From: Daniel Vick
Sent: 23 April 2018 17:20
To: Planning Scanning
Subject: FW: Planning Application: AL/115/17/OUT at Wings Nursery

From: [REDACTED]
Sent: 23 April 2018 14:51
To: Daniel Vick
[REDACTED] 'Gareth Giles | Whaleback'
Subject: Planning Application: AL/115/17/OUT at Wings Nursery

Further to our telephone conversation of the 30th I have now had a chance to look at your proposed site layout plan at the former Wings Nursery and have also read Bernie Harverson's comments. Although the proposed site layout plan doesn't show the root protection areas of existing trees it does appear that, with the exception of the category B English oak (T13), the siting of buildings and roads are within the developable area identified in our report (**Beechdown ref: B/0173/17**).

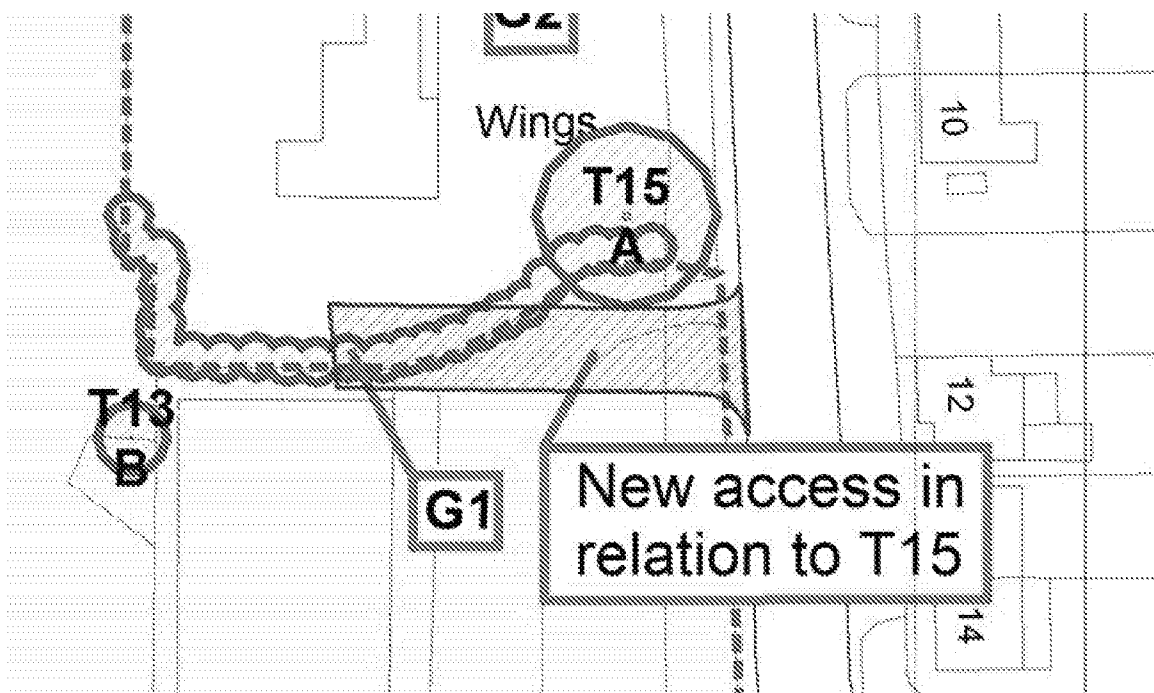
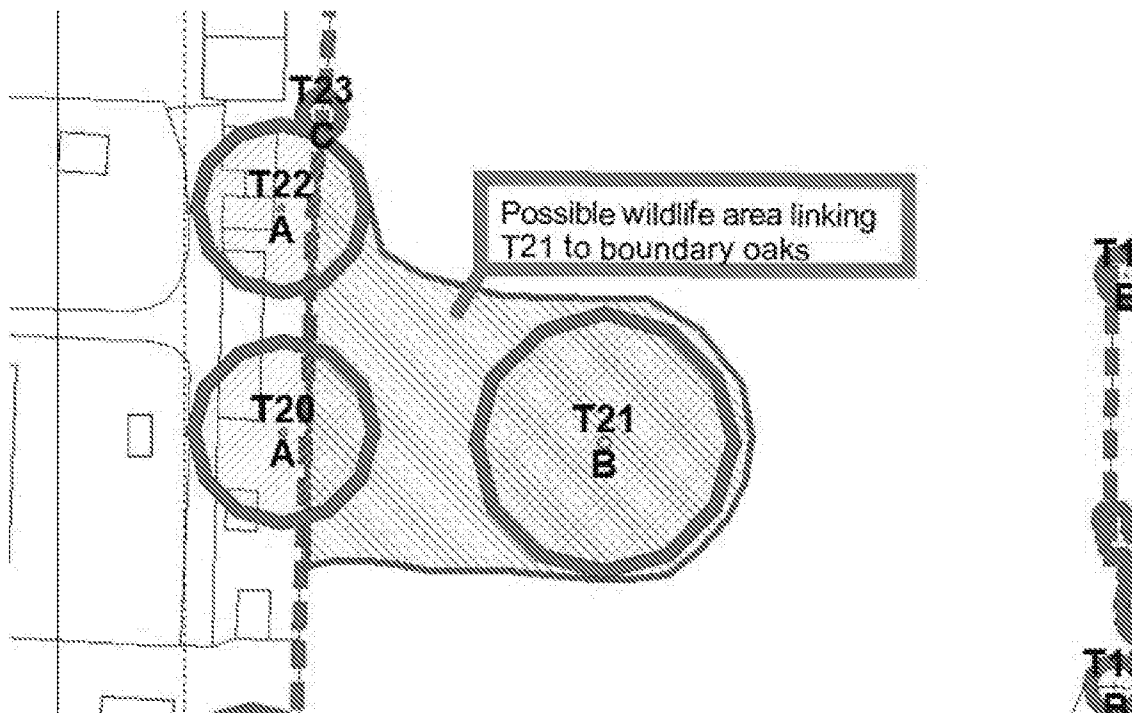
With regard to the prominent category A English oak (T15) in the grounds of Wings, there is an existing access from Lidsey Road where the main drive is indicated on your plan and as far as I can tell, although construction of the driveway will require the removal of part or all of the category C Leyland cypress hedge (G1), the northern edge of the proposed access drive barely reaches the southern extent of T15's RPA (see below) so it needn't be removed; however, tree protection, supervision and monitoring, as detailed in a conditioned method statement will have to be adopted to ensure that no damage to the roots or rooting environment occurs.

Construction of dwelling 55, although close to the category B English oak (T12), takes place beyond its RPA so it could be retained in the short –term; however, as the tree increases in size there may be pressure for future removal or excessive pruning. The proposed site layout plan indicates there will be extensive tree planting. Where space allows this planting should include specimens of English oak, sweet chestnut and perhaps field maples – native species that can attain large proportions and add maturity to the development proposal.

The veteran oak (T21) is identified as a tree with valuable habitat potential that should be retained and managed for both habitat and risk. The site layout plan shows a relatively large area around it and to the south-east that is undeveloped but a car-park between it and the western boundary. Although, with suitable working practices, construction of the car-park need not impact upon the RPA of the tree I am concerned that it may become a little isolated towards the middle of the site. If the parking spaces could be repositioned somewhere to the south-east of the tree and dwellings 16, 17, 18, 19, 20 and the flats moved marginally to the south then it may be possible to keep a wild area linking T21 (see below) to the mature oaks beyond the western boundary. The existing coppiced field maple, elder and grey willow could be retained along with additional planting of low level, scrubby native species i.e. hawthorn, blackthorn, hazel, spindle, guelder rose etc. As well as the potential wildlife benefits this planting would limit pedestrian access to base of the tree and reduce the potential for soil compaction within the RPA. Restricted access to the tree would also reduce the risk of injury in the event of stem or branch failure and may allow habitat features – branch fractures, major deadwood etc. – to be retained that may otherwise have to be removed if the tree is in an area of easy open access.
